**KIRKLEES METROPOLITAN COUNCIL
TOWN AND COUNTRY PLANNING ACT 1990
HIGHWAYS DEVELOPMENT CONTROL KP20H**

PLANNING REF 2012/62/92626/W0/JS
CATEGORY Minor

PROPOSAL ERECTION OF ONE DETACHED
DWELLING WITH INTEGRAL
GARAGE(MODIFIED PROPOSAL)

LOCATION CROSSWAYS
NIELDS ROAD
SLAITHWAITE
HUDDERSFIELD
HD7 5HT

Drawn: BRT	Date: June 2011
Checked: JC	Scale: 1:100, 1:200
Drawing number:	2191 / 02C

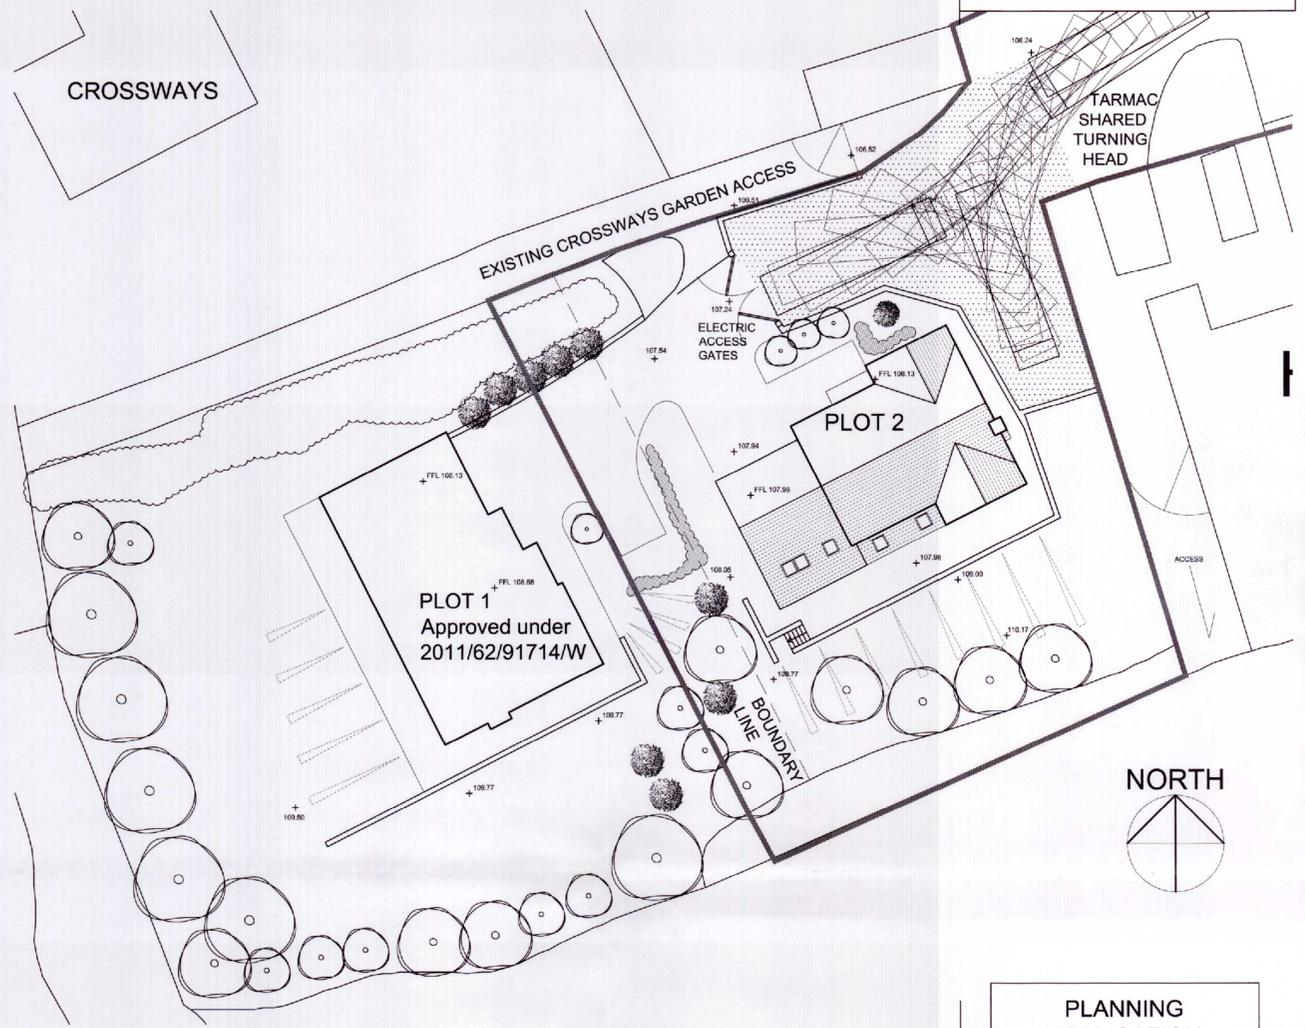
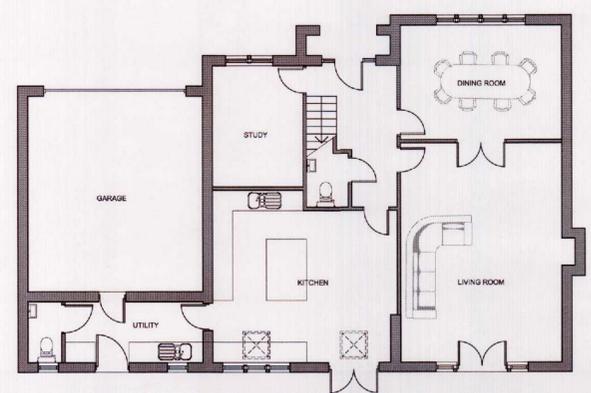
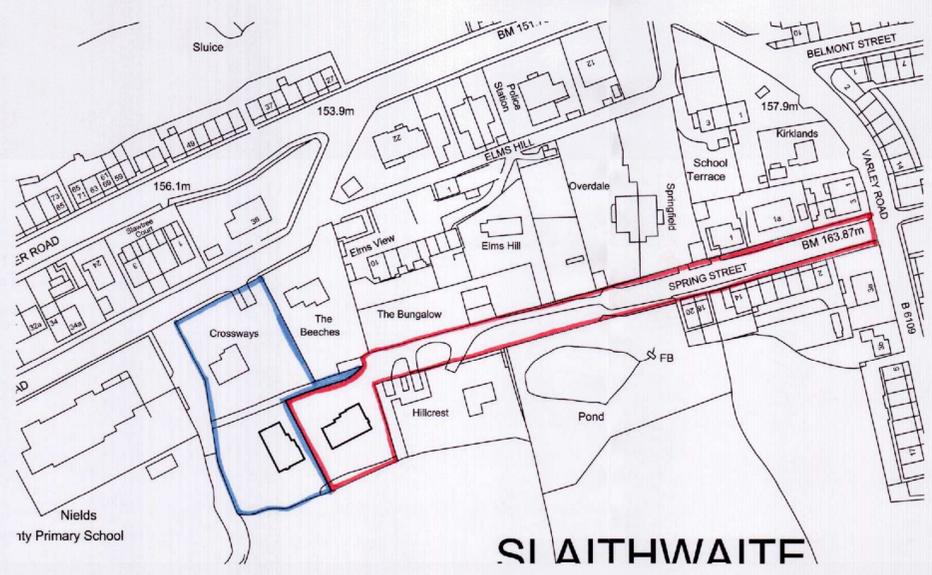
With reference to plan 2191/02C the development shall not be brought into use until all areas indicated to be used for parking and turning on the approved plan(s) have been laid out with a hardened and drained surface in accordance with the Communities and Local Government; and Environment Agencies 'Guidance on the permeable surfacing of front gardens (parking areas)' published 13th May 2009 (ISBN 9781409804864) as amended or any successor guidance; Notwithstanding the provisions of the Town and Country Planning (General Permitted Development) Order 1995 as amended (or any Order revoking or

Drawn: NG Date: FEB 2013
 Checked: JC Scale: @ A0
 Drawing number: 2191-003B

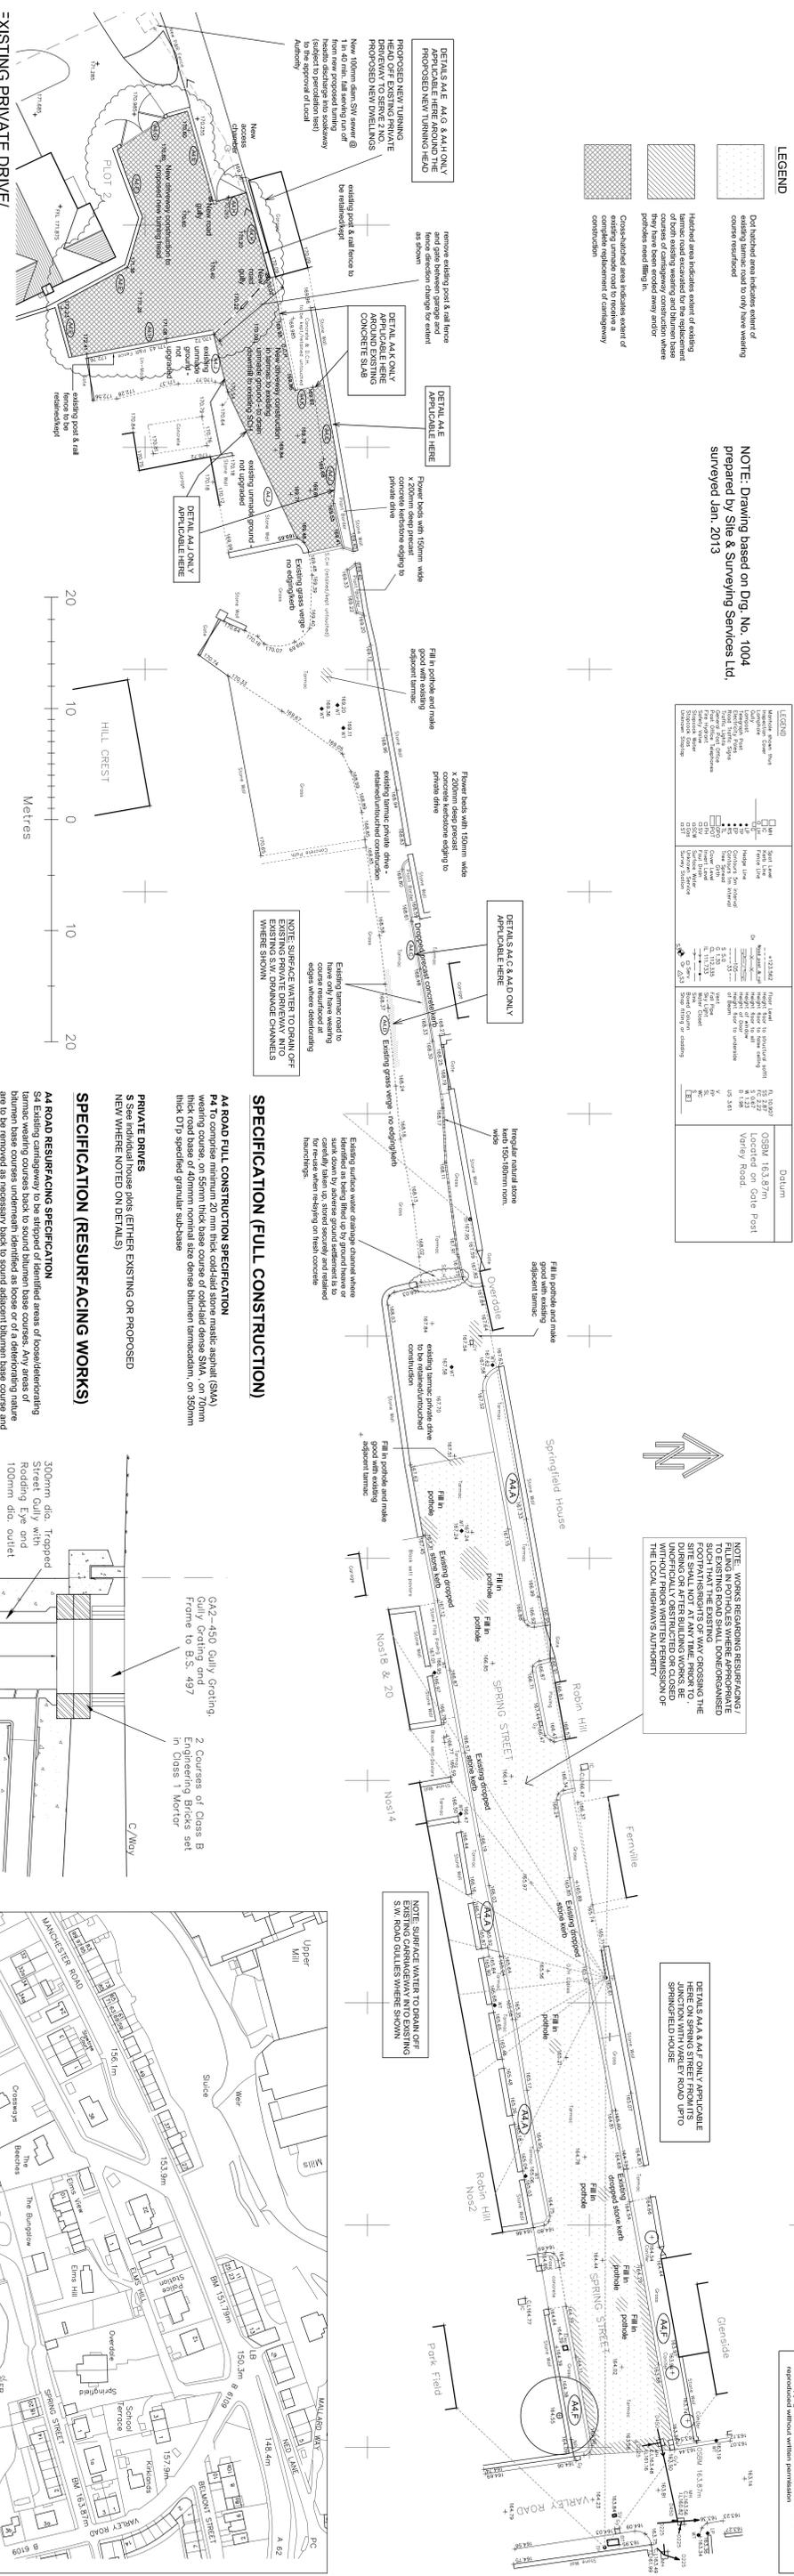
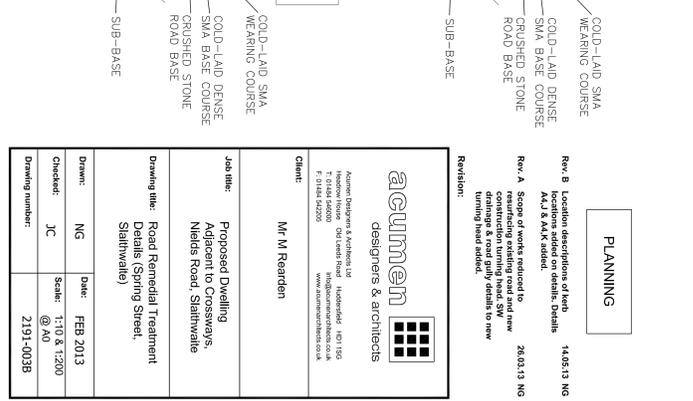
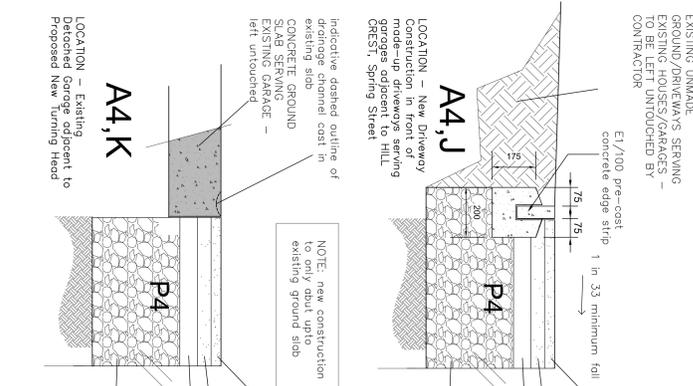
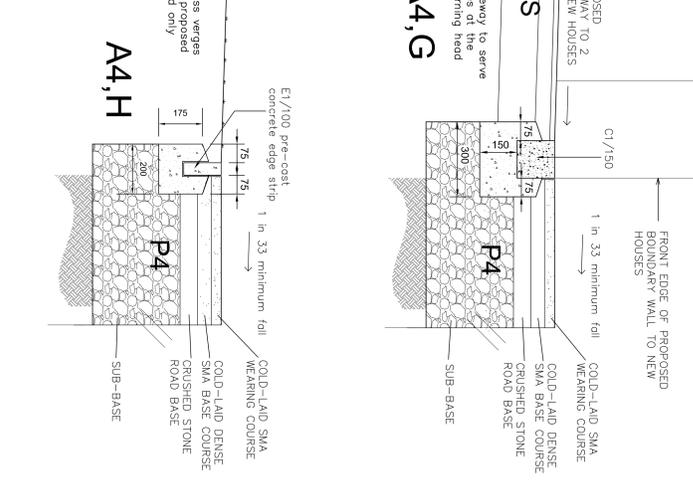
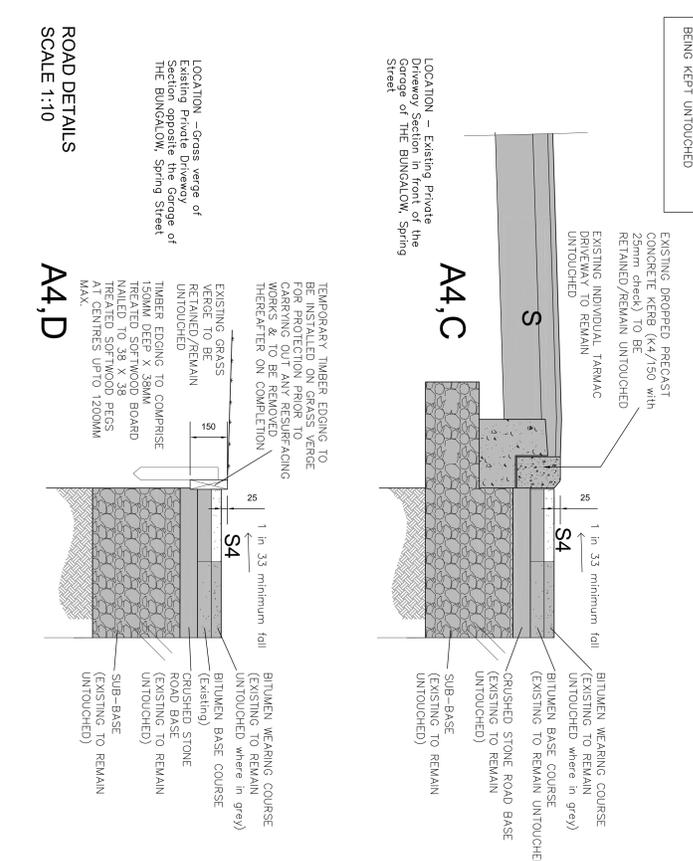
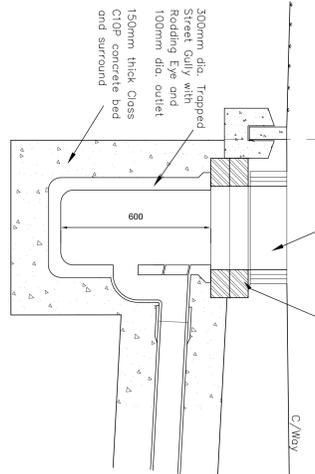
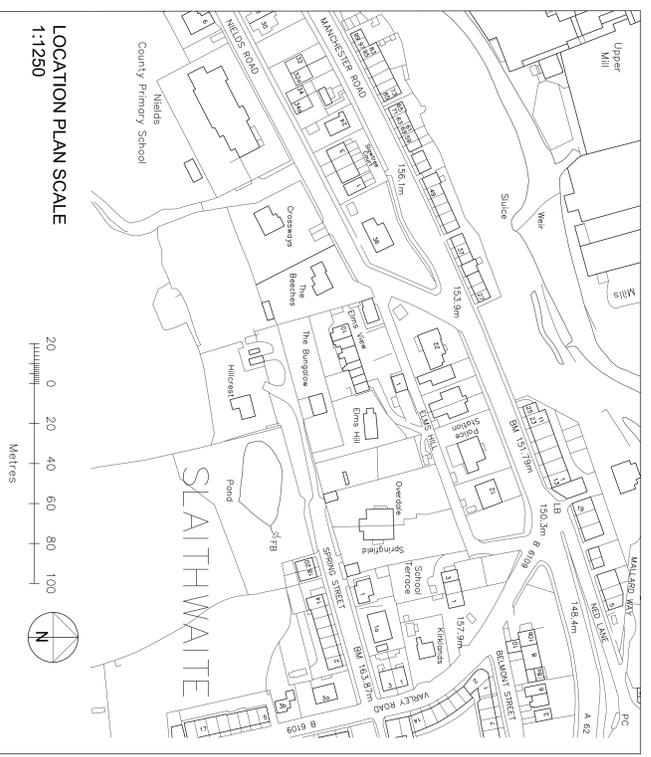
The application proposes the erection of one detached dwelling at the end of Spring Street which is unlit, un-adopted and without the provision of a service turning head. It is approximately 200m in length which varies in width between 7.5m and 3.5m. The first 108m is a private street with the remainder forming a private road or drive.

It serves a combination of terraced and detached properties (approximately 17) and there is a gated field access near its western end. The carriageway is an unmade track for 90m and a combination of surfaced and unmade beyond and substandard in terms of drainage.

Concerns were previously raised by this service with regard to the deterioration of the existing carriageway surface of Spring Street and considered that any additional traffic movements along Spring Street would lead to conditions to the detriment of convenience and safety contrary to UDP policies D2 and T10 of the Kirklees Unitary Development Plan.

Since then a plan including a scheme of works has been received proposing road remedial treatment works along Spring Street. These works along with the proposed turning head are considered to give improvements to residents/users of Spring Street and therefore on balance makes this application acceptable from a Highways point of view.

With reference to the approved drawing no. 2191-003A; the development shall not commence until the approved works have been completed. The development shall not be brought into use until a scheme detailing a post development condition survey and remedial works for Spring Street has been submitted and approved by the local Planning Authority. The development shall not be brought into use until the approved remedial works to Spring Street have been completed.

Before any dwelling is occupied turning facilities shall be provided in accordance with the details shown on drawing no. 2191-003A. The turning facilities shall thereafter be made available for use at all times by vehicles and shall be kept free from obstruction to such use.
